Re: Public Comment - File No. 2207-019
6950 SE Maker Street/Parcel No. 9350900620

We own and live at the residence located at 7155 SE Maker Street, across SE Maker Street from the referenced project ("Project") proposed for 6950 SE Maker Street ("Site"). The Site is owned by The Strand Trust ("Strand"). Our home is on the south side of SE Maker Street and slightly east (uphill) of Project.

BUILDING ELEVATIONS

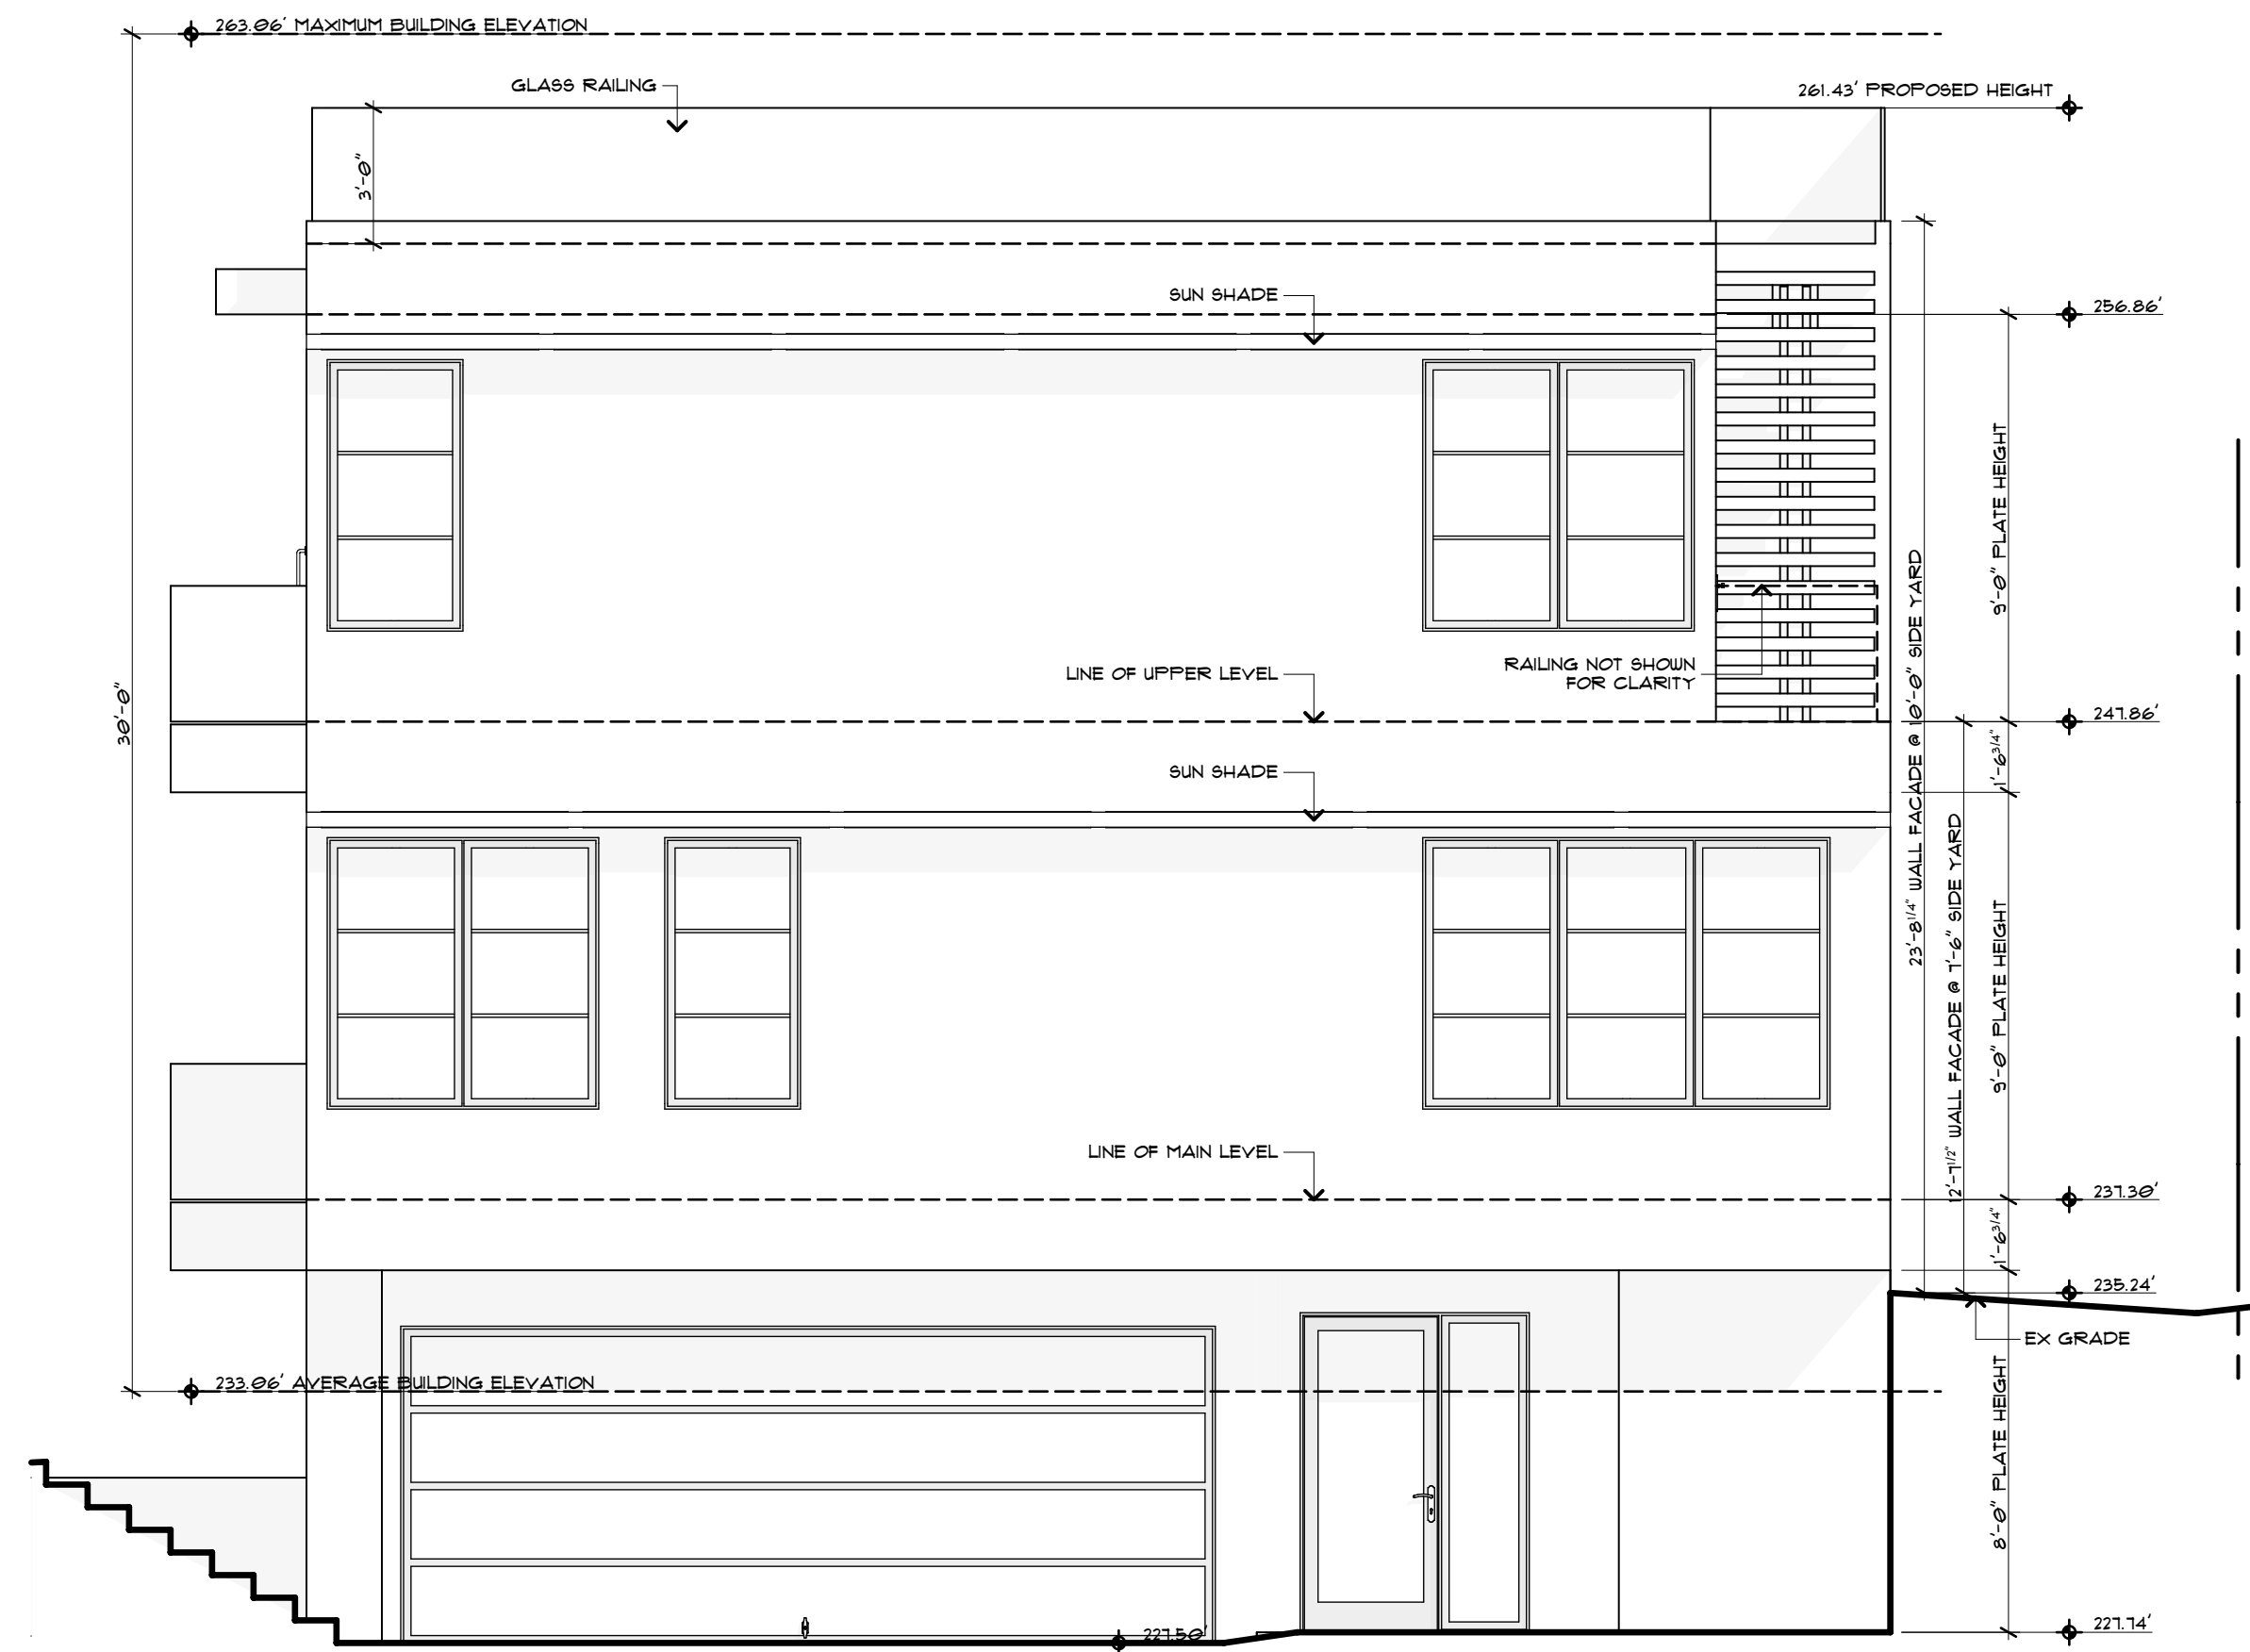
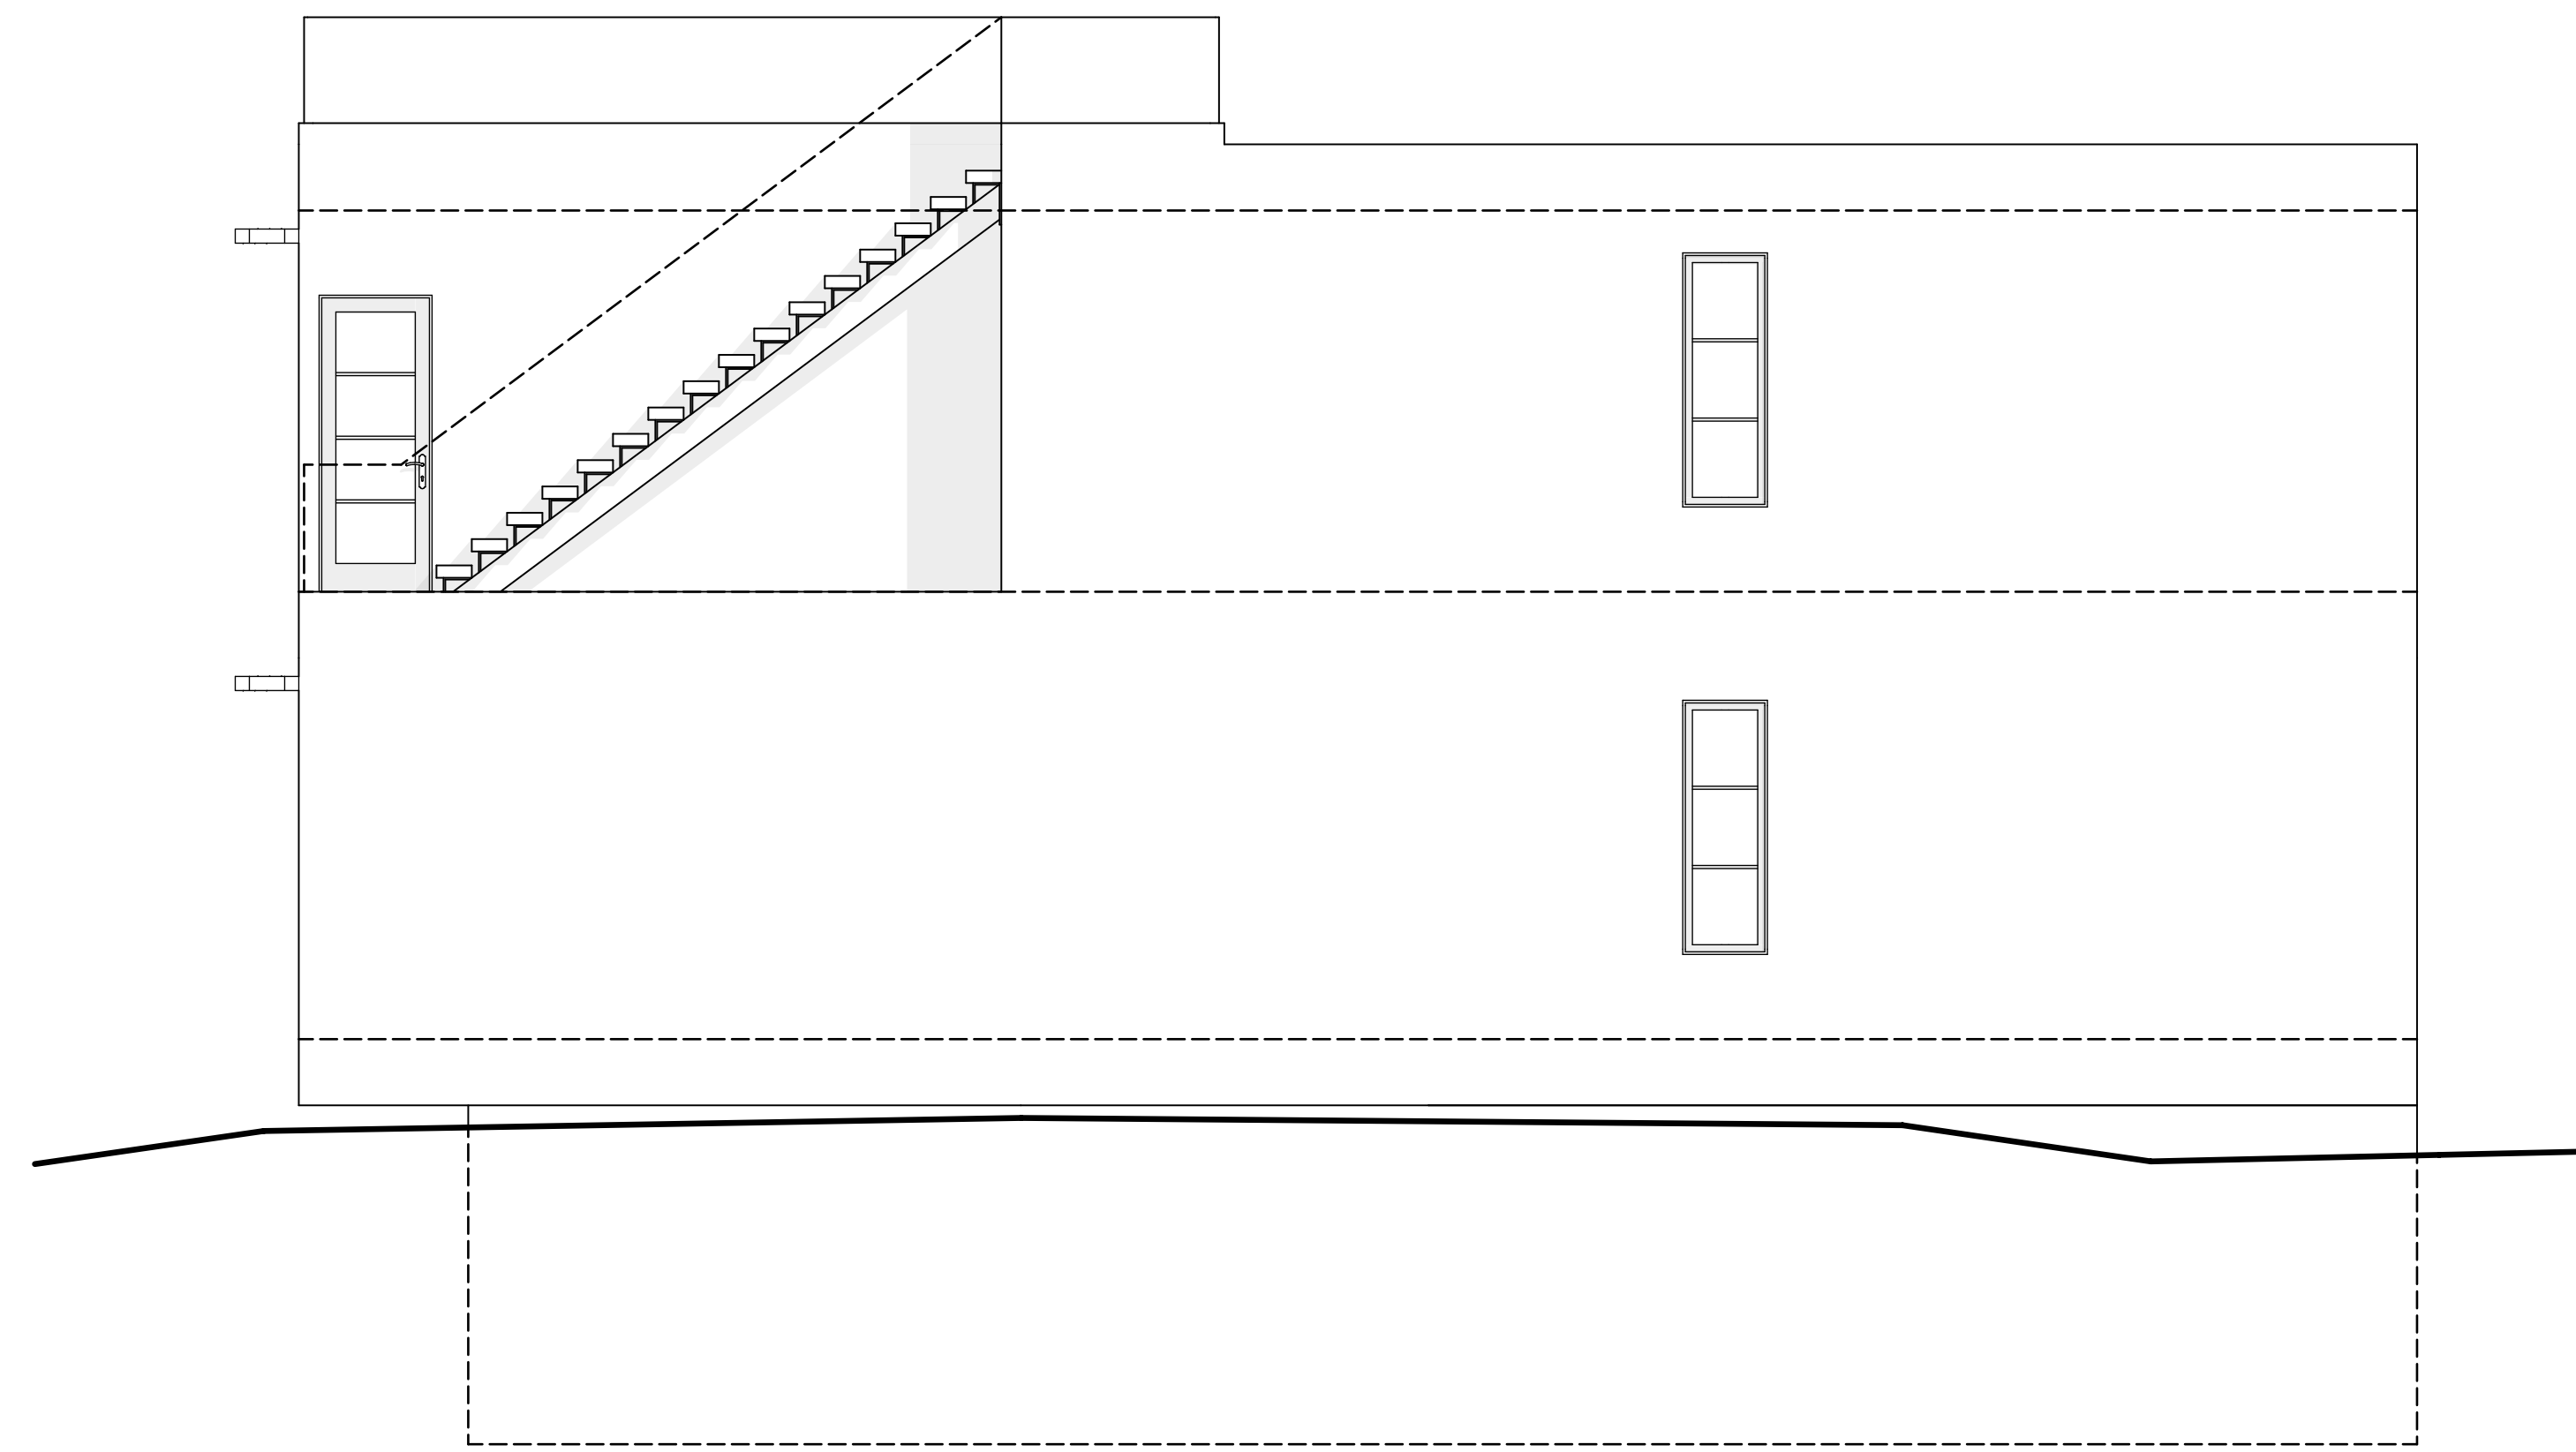
A. In particular, we share the concerns that the Project does not properly calculate the Existing Grade of the Site, as defined in MICC 19.16, in determining the permitted height for the Project. This results in a proposed residence that would be substantially taller than permitted by the MICC and would loom high above the rest of the homes in the neighborhood. We are also concerned that the rockery retaining walls that support a substantial amount of fill

Notwithstanding the substantial amount of fill located on the Site, the Proposal does not appear to use the Site's "Existing Grade," as defined by MICC19.16.010, to determine the permitted height of the proposed residence at the Site. Use of the appropriate Existing Grade, i.e., the grade prior to bringing a substantial amount of fill to the Site, would reduce the permitted height of the proposed residence by several feet, creating a structure less out of scale to the neighborhood and in compliance with the MICC.
